Our ref: Maroubra - Affordable Housing Redevelopment-Mod-1 (SSD-71454960-Mod-1)

Subject: Request for Additional Information

I refer to the modification application (Mod-1) to the Yorktown Parade and Fitzgerald Avenue, Maroubra - Affordable Housing Redevelopment-Mod-1 (SSD-71454960-Mod-1). We have placed the Randwick City Council's and agency comments on the NSW Planning Portal at:

T12 *Cupaniopsis anacardioides*

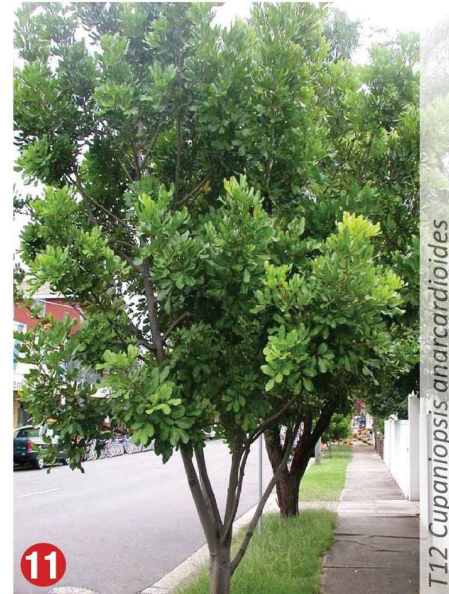
- Update the tree species schedule to reflect Council's recommendation that Tuckeroo's (*Cupaniopsis anarcardioides*) are no longer suitable in the Maroubra area.
